Application for a non-material amendment following a grant of planning permission.

Extension of existing sewage treatment works including erection of operational structures, kiosks, fencing and upgrades to track and hardstanding

Reference number: 21/00498/FUL

Drawing Number: ET38-MMB-00-XX-DR-T-00110

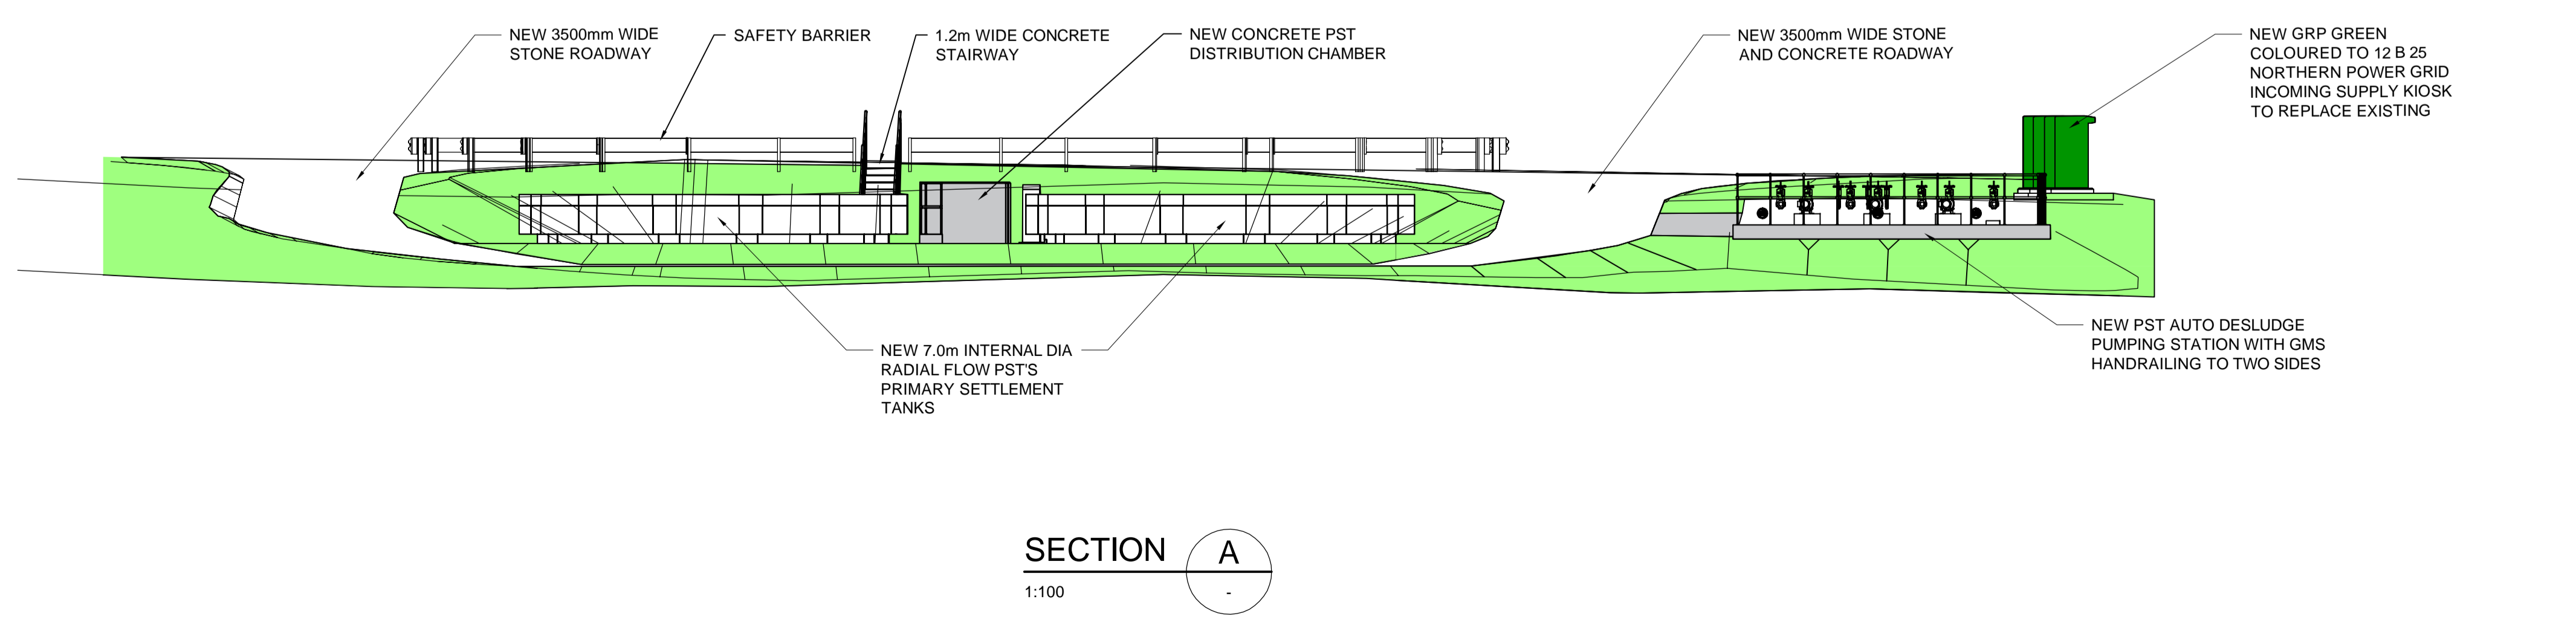
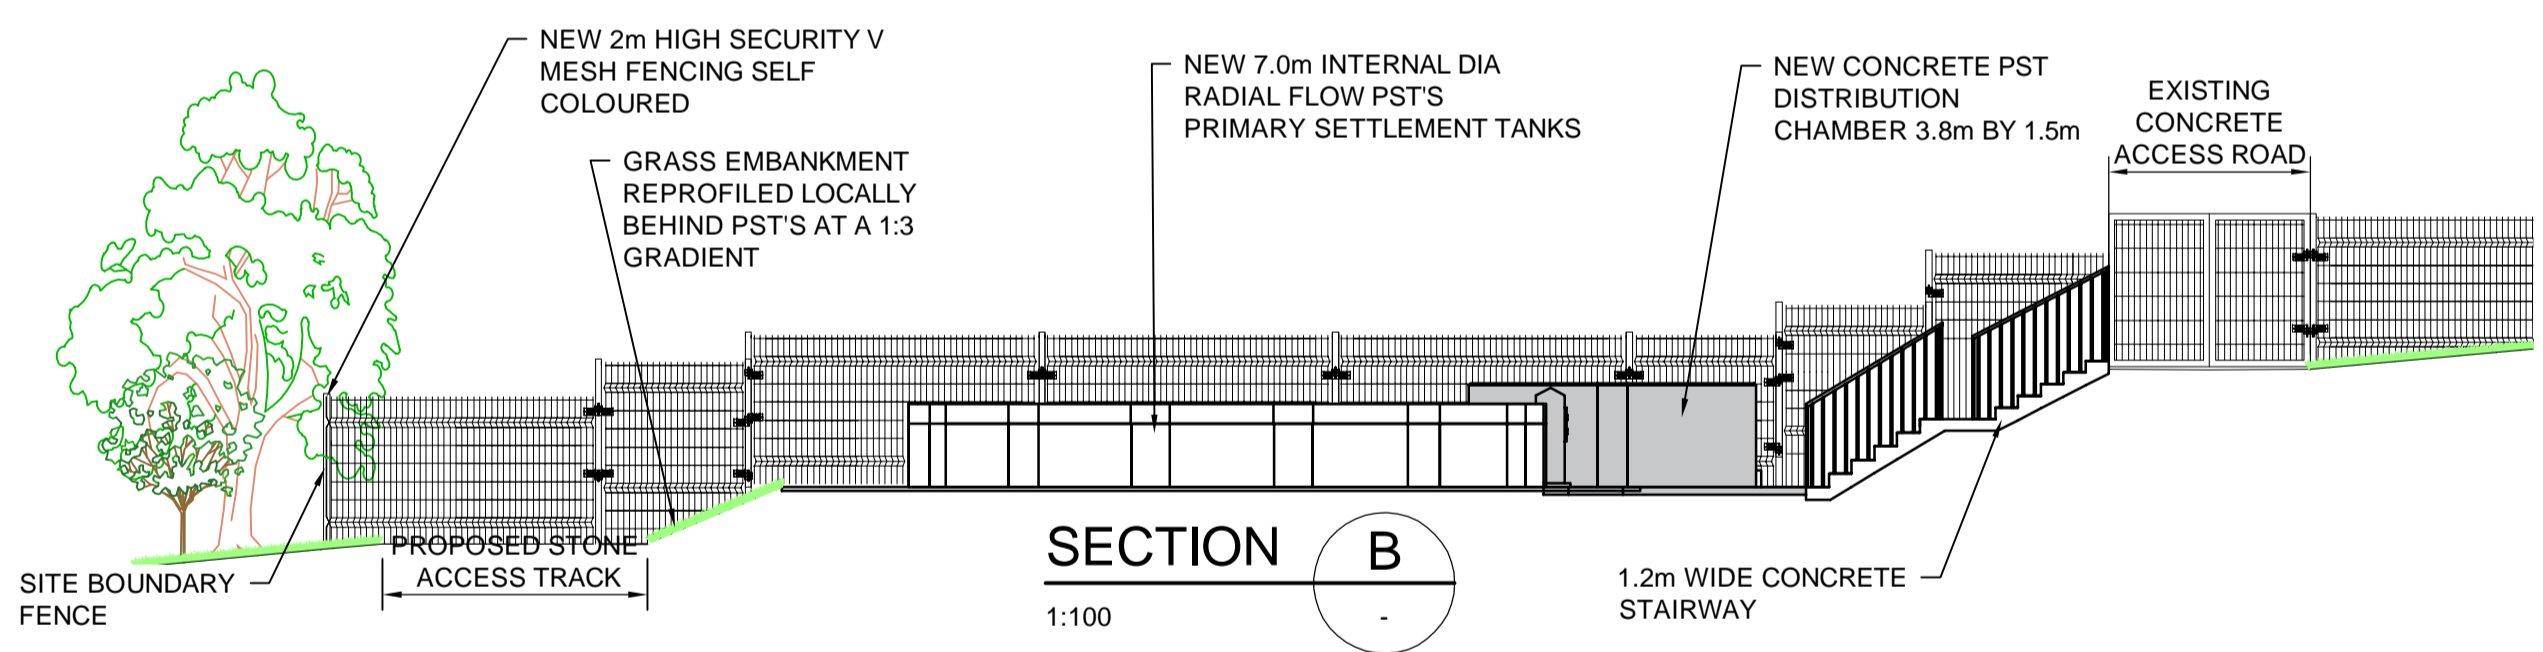
- A shorter MCC building kiosk (11.5m instead of 12.6m);
- The switch in position of the Motor Control Centre ('MCC') Building and the Tertiary (HSAF) Treatment Plant;
- Relocation of the Final Effluent Sampling Chamber to be adjacent to the HSAF Plant;
- The provision of a vehicle safety barrier along the road above the Primary Settlement Tanks (PSTs);
- Rationalisation of road turning circle radii; reduced area of concrete hardstanding at the PSTs; and reduced internal diameter of the new PSTs from 7.1m to

7.0m;

ET38-MMB-00-XX-DR-T-00105

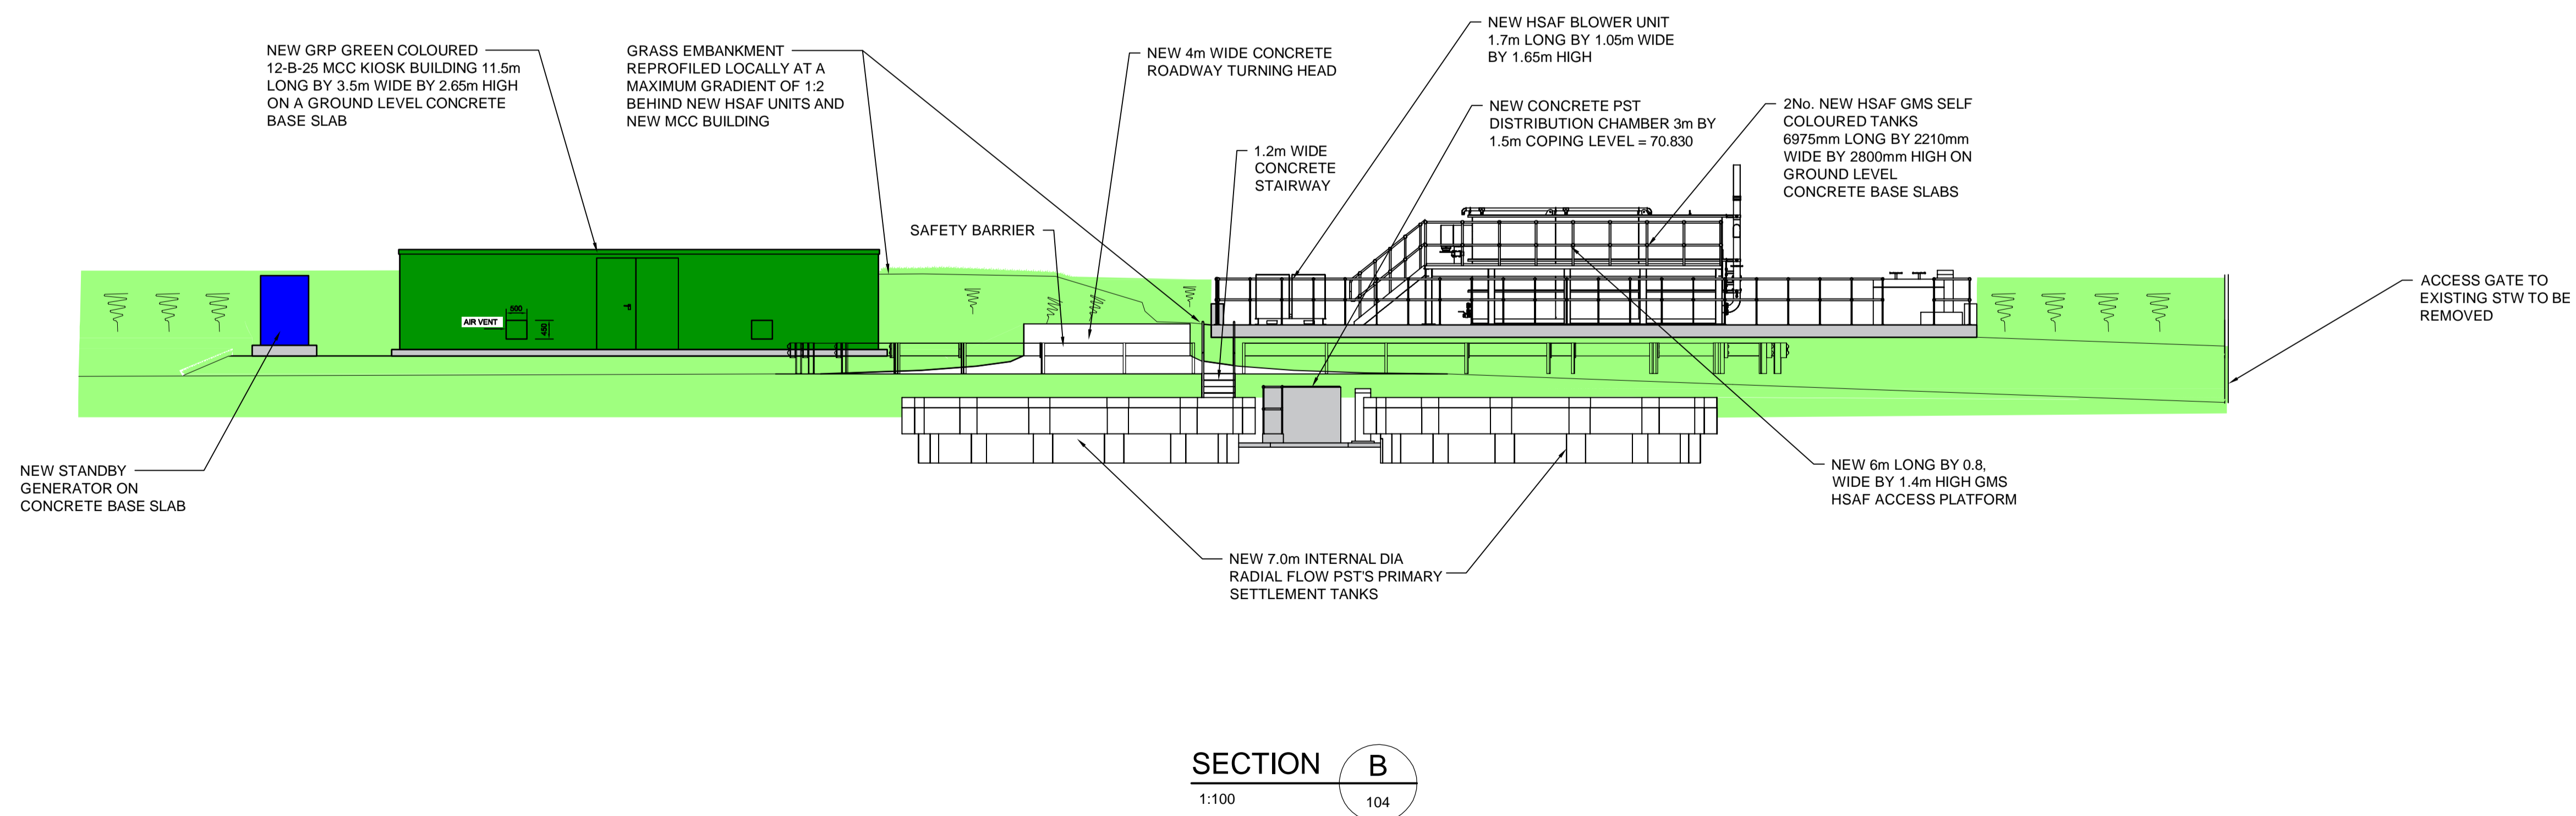
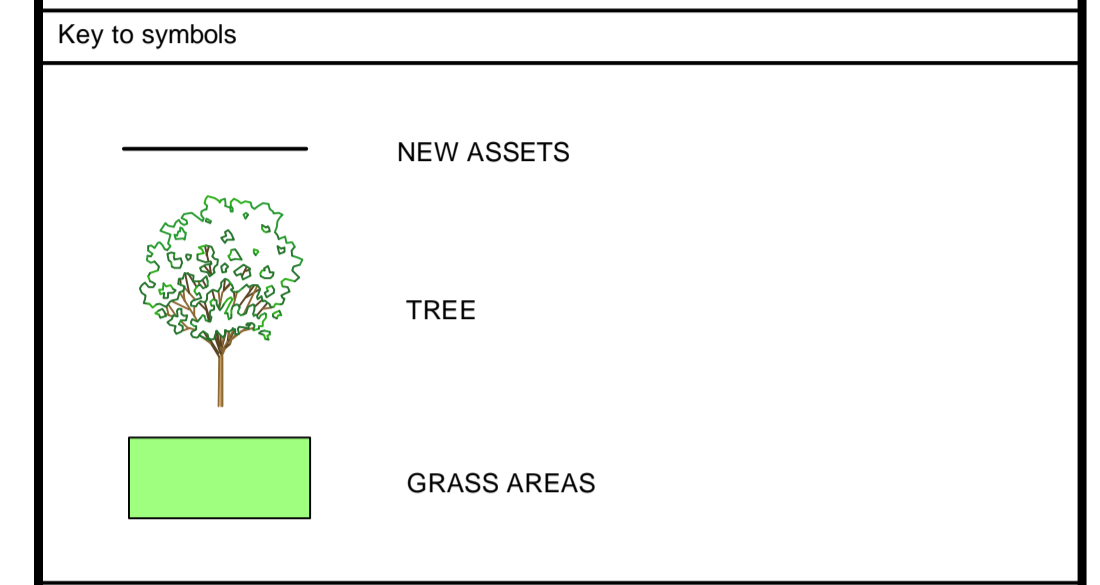
- The requirement for a new Incoming Power Supply Kiosk (internal dimensions 2100mm long by 750mm wide by 1800mm high) adjacent and to replace the existing kiosk for an increased power supply from NPG;
- The MCERTS flow meter chamber will comprise a manhole with open-mesh decking instead of a rectangular chamber with access cover; and
- Minor changes to proposed Finished Ground Levels and slopes.
